Our ref: OUT25/8157

Subject: Hillview Hard Rock Quarry (SSD-70557215) – Environmental Impact Statement

### Detailed advice to DPHI Planning & Assessment regarding the Hillview Hard Rock Quarry (SSD-70557215) – EIS

## 7.0 Water Balance Modelling

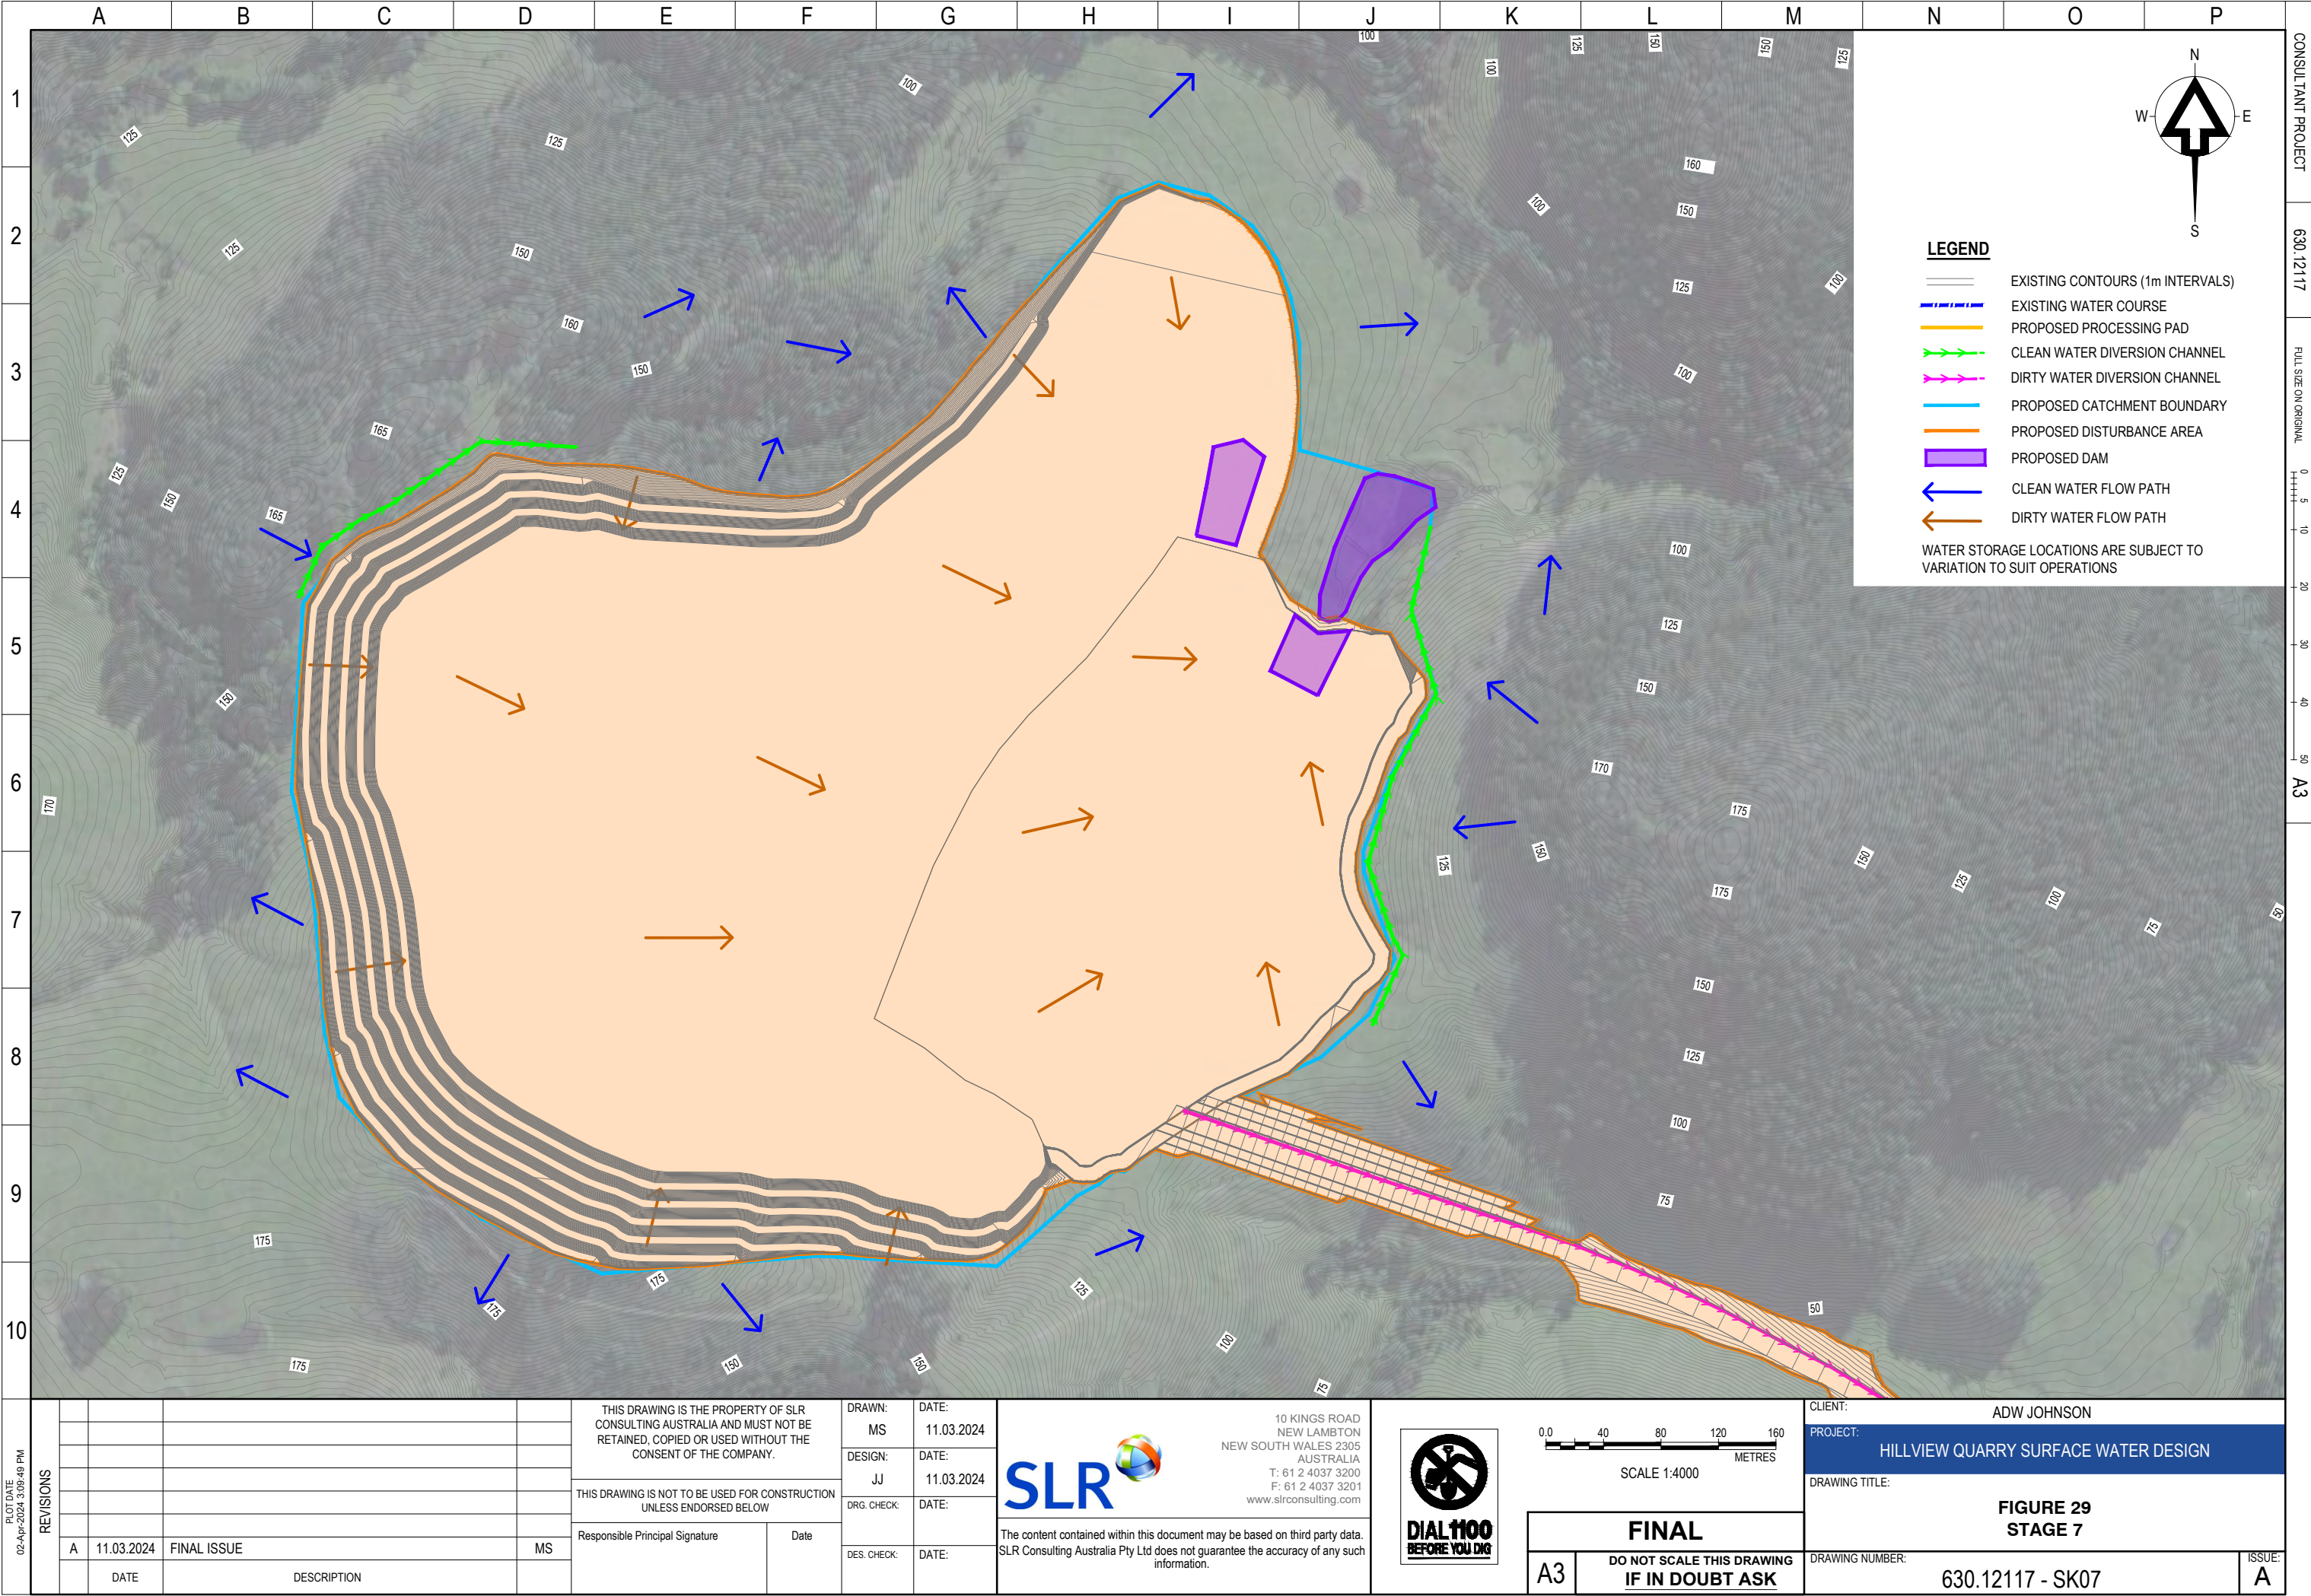
The proposal includes several dams/basins which need to be considered against the water licensing framework. This should consider the harvestable rights capacity, exclusions under Schedule 1 of the *Water Management (General) Regulation 2018* or the requirement to obtain entitlement. Figures 24-29 and 49 of the Surface Water Assessment show that an existing 'Farm Dam' is proposed to be converted to a sediment dam at the outlet of the quarry. This dam is on a third order stream so would not meet the definition of an excluded work under Schedule 1 of the WM (General) Regulation as it is not located on a minor stream.

Dams on third order watercourses do not meet the Departments Guidelines for Controlled Activities on Waterfront Land – Riparian Corridors. It is generally requested that water quality treatment occurs offline.

The Department of Planning, Housing and Infrastructure request the proponent to review the proposed surface water structures to confirm the requirement for water licensing or where an exemption may apply. This is to include a review against:

- The excluded work provisions under Schedule 1(4) of the Water Management (General) Regulation 2018. Further information is available at: [https://water.dpie.nsw.gov.au/\\_data/assets/pdf\\_file/0008/554444/excluded-work-exemption-fact-sheet.pdf](https://water.dpie.nsw.gov.au/_data/assets/pdf_file/0008/554444/excluded-work-exemption-fact-sheet.pdf)
- Maximum harvestable rights dam capacity where dams are located on minor streams and capture runoff.
- The requirement for licensed entitlement where the water capture/use is not exempt or excluded, and to demonstrate this can be obtained in the relevant water source.
